February 17th 2022**By e-mail only:**

21/04275/OUT: Land Adjoining Lords Lane And SE Of Hawkwell Farm, Lords Lane, Bicester**1. Background, and scope of the development proposals**

Stagecoach is pleased to offer its comments and representations on the proposals for a Mixed Use Development of up to 3,100 dwellings, supporting facilities, infrastructure and land uses on the site referenced above.

Bicester, NW
Development Framework Plan

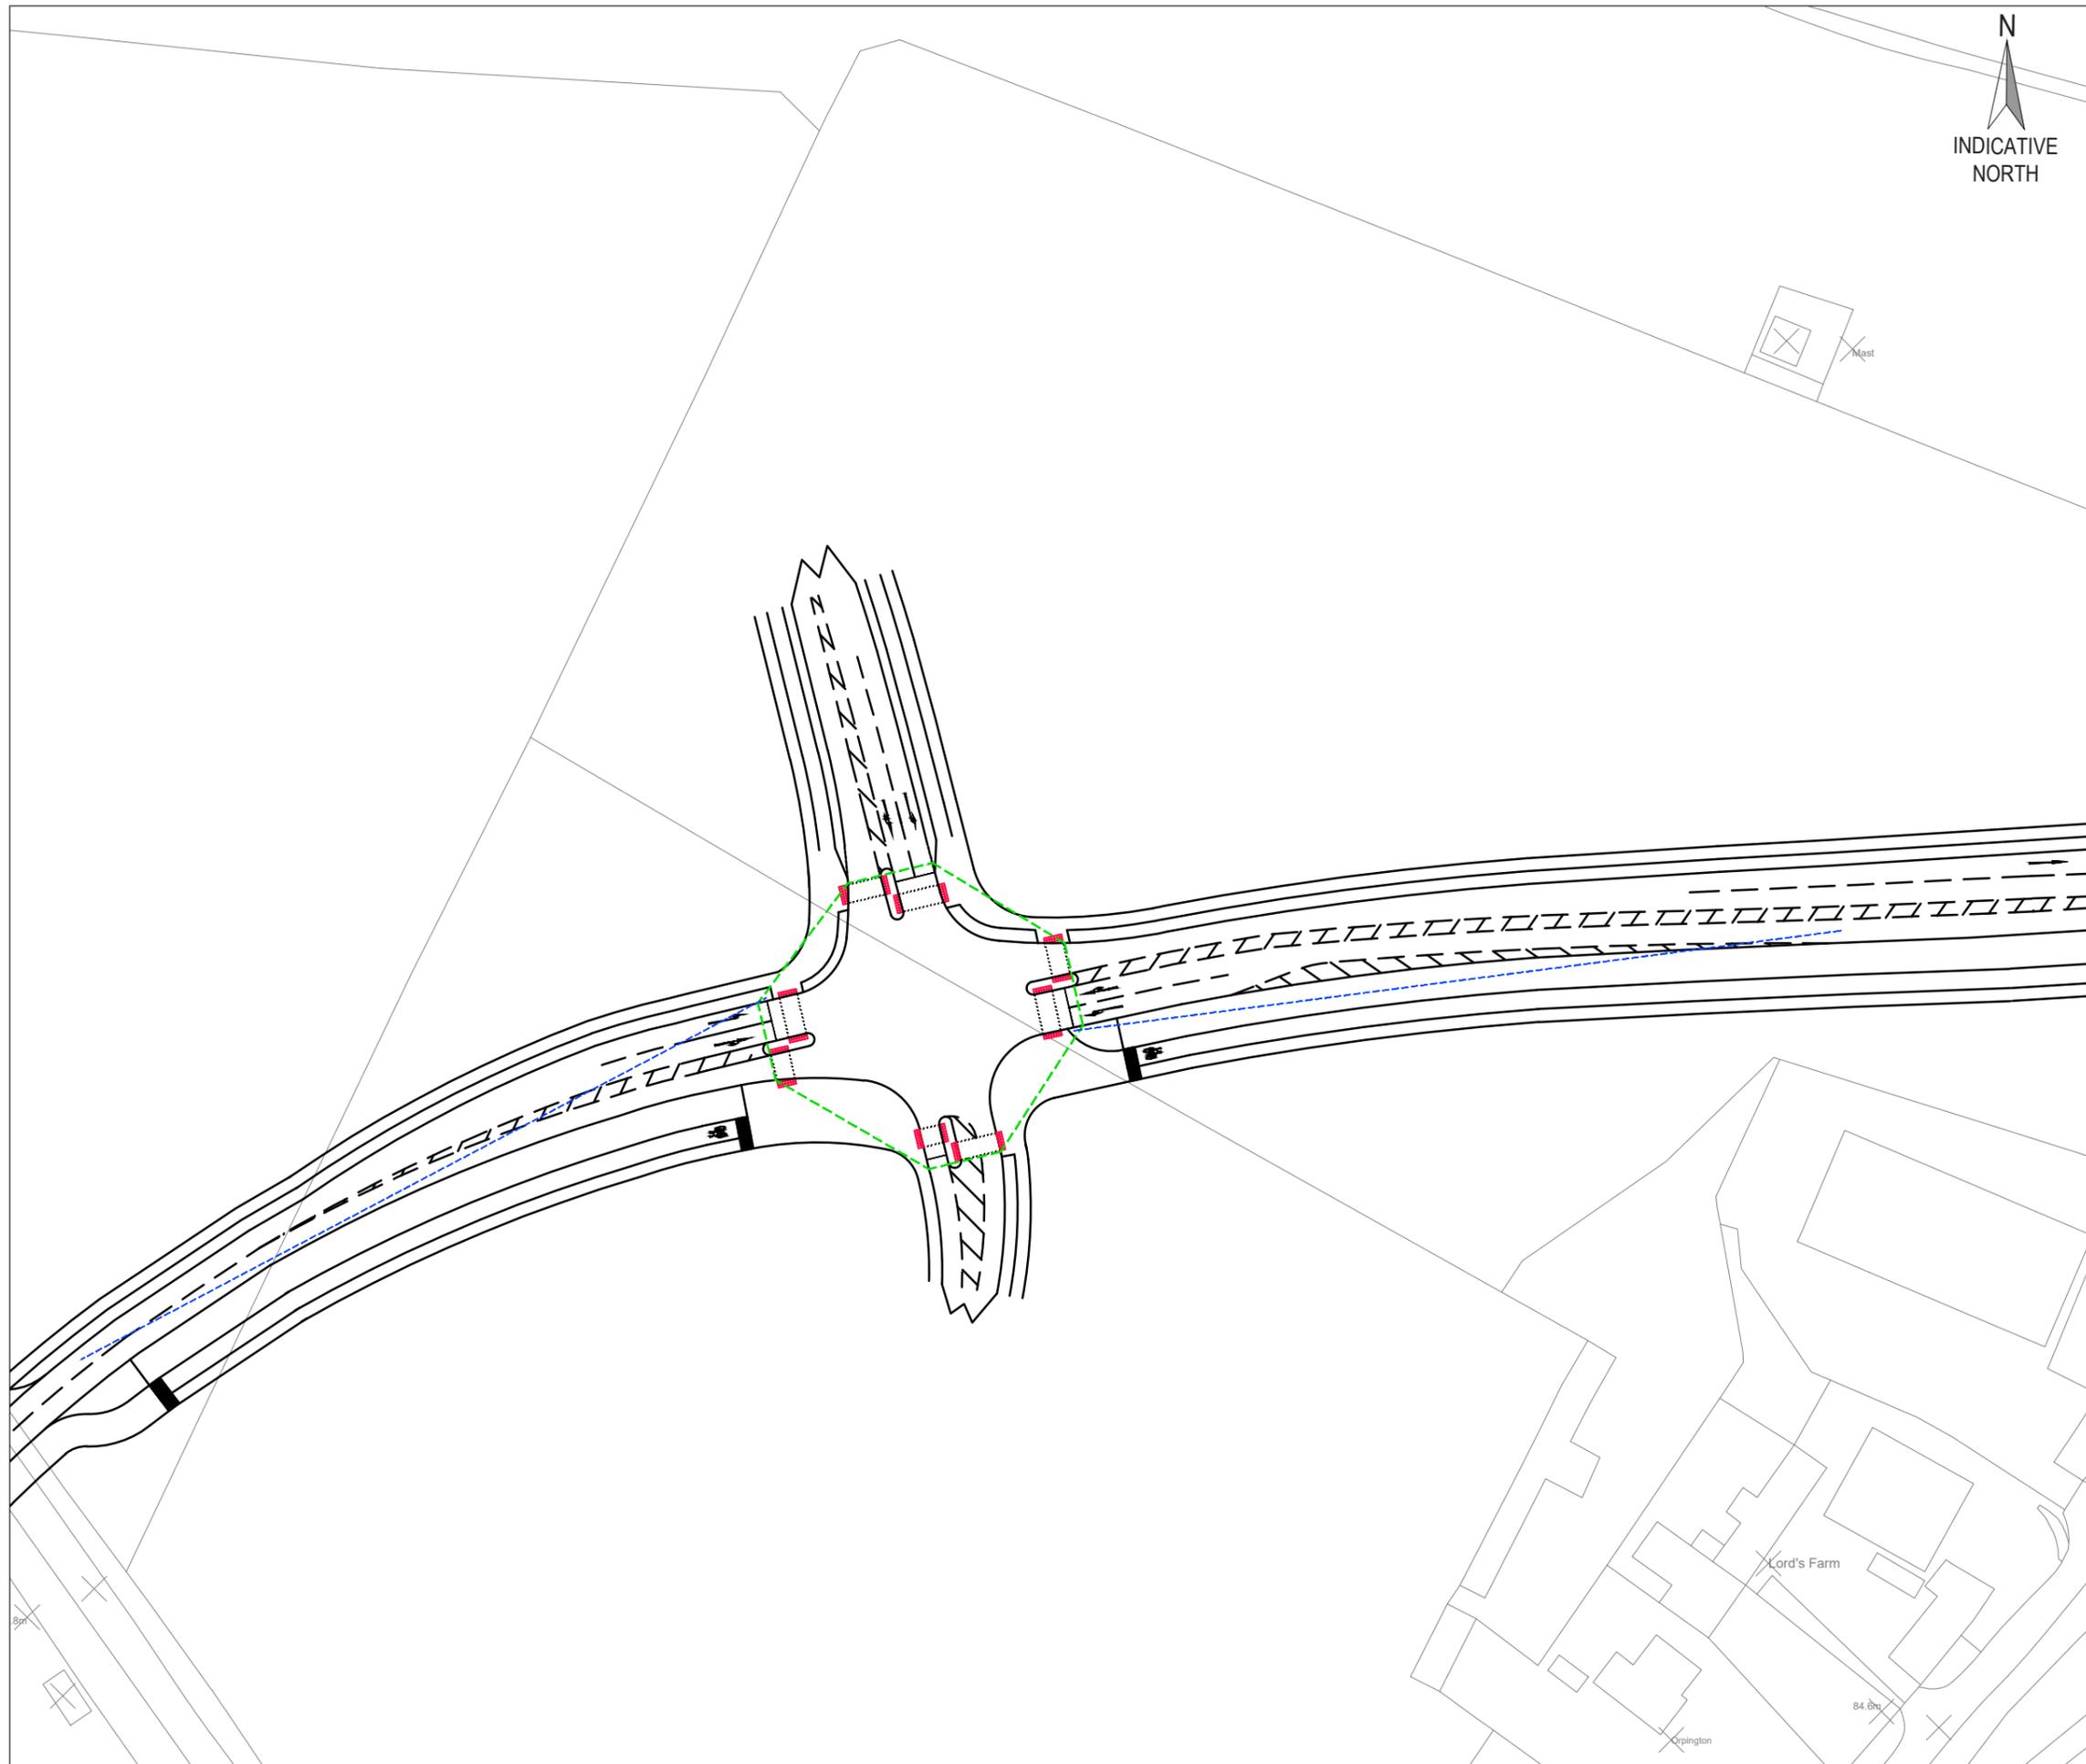
The Framework Master Plan, commendably, proposes a simple and reasonably direct “primary street” through the site, running from the A4095 in the south east, back towards the A4095 at a point on the proposed Howes Lane Relief Road east of the Bucknell Road at the proposed mixed use local centre. This is anticipated by the applicant to accommodate the bus route. This revised approach is broadly somewhat better than the rather more indirect and intricate route previously anticipated in the SPD.

However, it is aligned in such a way that extensive areas of the development are likely to lie further than 500m away from a bus service, especially towards the north and west of the site. This does not optimise the relevance of public transport to the broadest number of residents, as the public transport strategy ought.

The proposed primary street alignment also leads to an unhelpfully indirect routing as the bus leaves the main radial Bucknell and Banbury Roads or picks them up to return to town, especially on the western flank of the scheme. On the eastern side of the development it would probably be preferable to continue up the

However, on the western side of the development it appears much more appropriate to seek to slightly extend the main street loop to pass to the north and west of the existing Hawkwell Farm complex (that lies outside the redline) and tie into Bucknell Road. This might take the form of a displaced priority junction that incorporates the existing road into the development circulation route. Bucknell Road would need to be widened and possibly reinforced. We note that it is already proposed to divert Bucknell Road into the site at the Secondary School site as it approaches the A4095. This arrangement would need to be slightly adjusted to increase carriageway width and ensure that geometry would properly accommodate the function of the road.

This more northerly alignment has a number of other benefits, one of which is that the main street does not need to cross the main open space “green loop” corridor that runs along the River Bure, at its widest point, making that area much better able to function as a unity, for all kinds of recreational, ecological and hydrological purposes. It also ought to help mitigate development infrastructure cost, which will inevitably be high on a project of this scale. Finally, and follow from the preceding point, it might from first principles prove to be easier to deliver the full spine road at a somewhat earlier stage in the development life cycle, with very great benefits to the ability to provide a bus service to all residents sooner rather than later.

The bus route spine really needs to tie in, as seamlessly as possible, to the Bucknell Road south of the railway. The current main access point on the proposed Howes Lane Relief Road at the local centre anticipates four arms, the southern one currently intended merely to provide development parcel access. This could easily be amended to create a direct route for sustainable modes leading straight to the existing skew bridge. This would directly help sustain higher mode shares for sustainable modes, as motorised traffic at this point would be forced to use the realigned A4095 to the east or west and this offers a very much less direct route to the town centre and other key destinations such as secondary schools and the station.

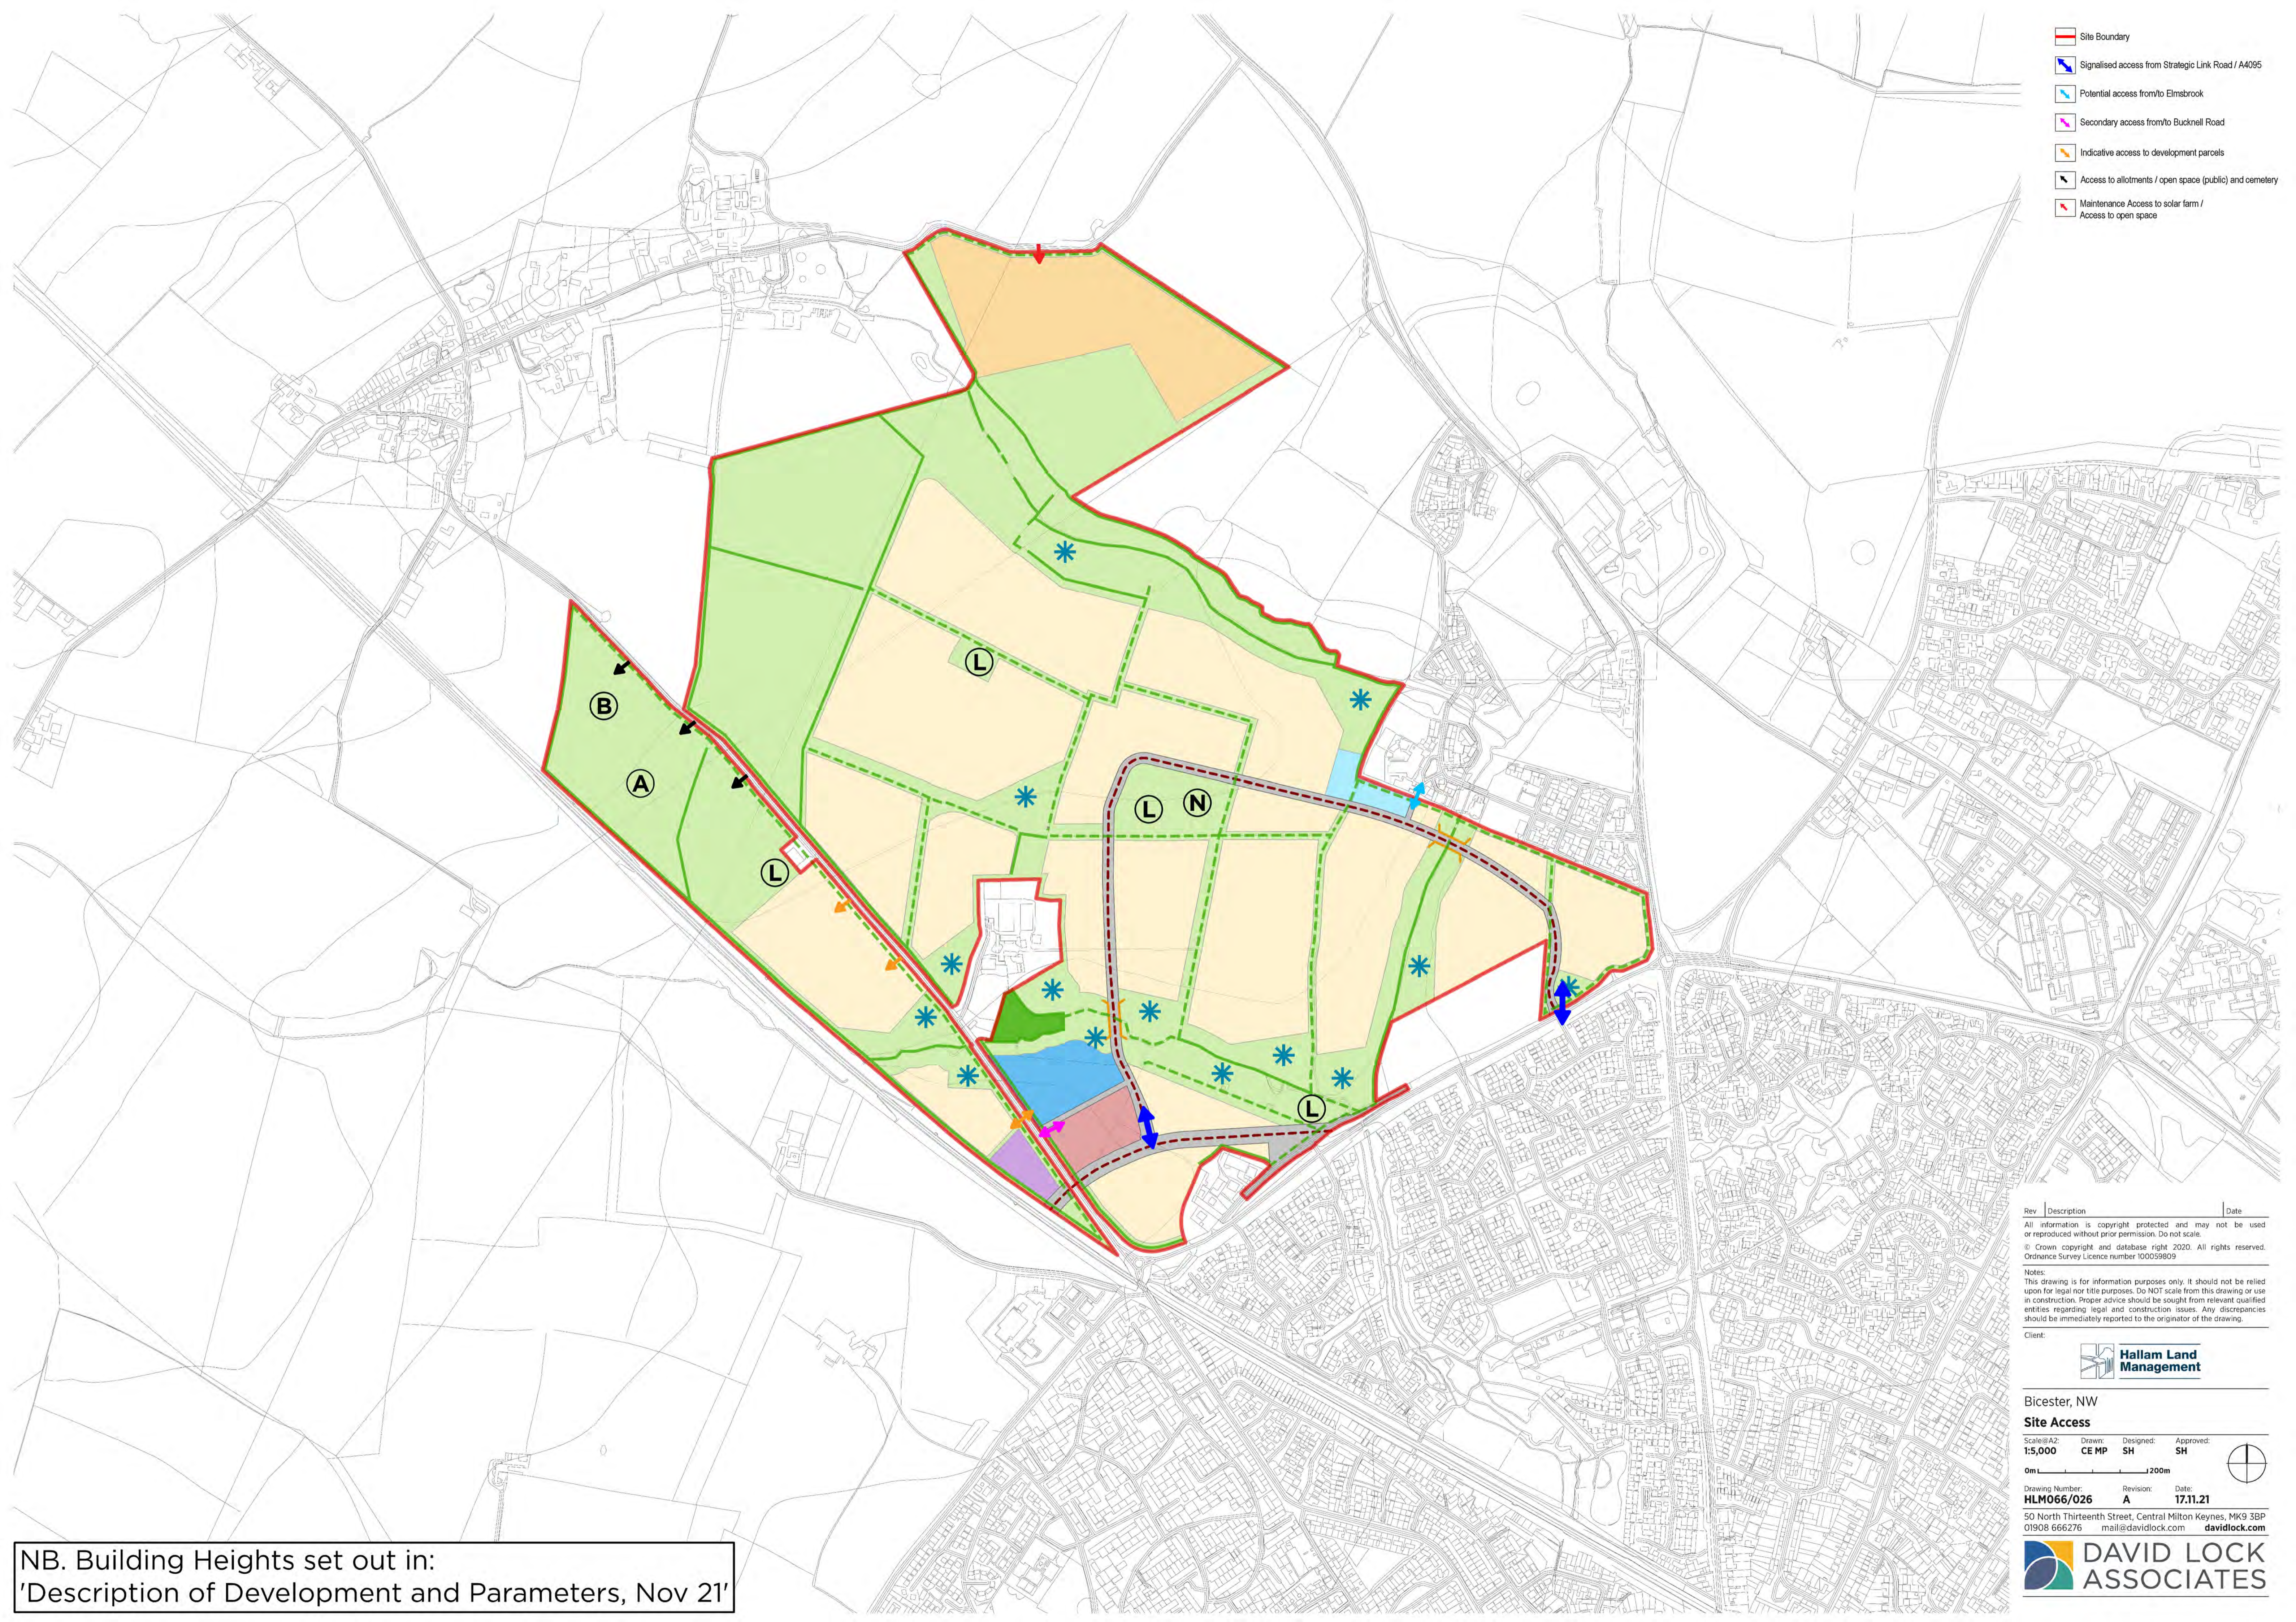
It must first be emphasised that the Master Plan submitted with the application, including the movement and access parameters plan, diverges quite materially from the overarching Ecotown Master Plan that steered the 2014 applications.

The approach to siting bus stops is confused, as it is unclear the basis on which the route is intended to circulate, especially with regard to the tie-in to the Exemplar site. The level of detail provided to explain the positioning of the stops in the DAS at page 88-90 is inadequate. We do not understand the design logic for the positions suggested. To provide only two bus stops on a development of this kind runs entirely counter to established practice and diverges even more from good practice advice promulgated by the relevant professional body, the Chartered Institution of Highways and Transportation, as well as ourselves, with which the applicants consultants should be well apprised. The provision is “minimalist” to a degree that is quite troubling. Set against the approach and care given to cycling this presents a stark contrast.

Finally, we would urge that the applicant assumes that the bus route runs in two directions through the site and that street geometry and bus stops are sited accordingly.
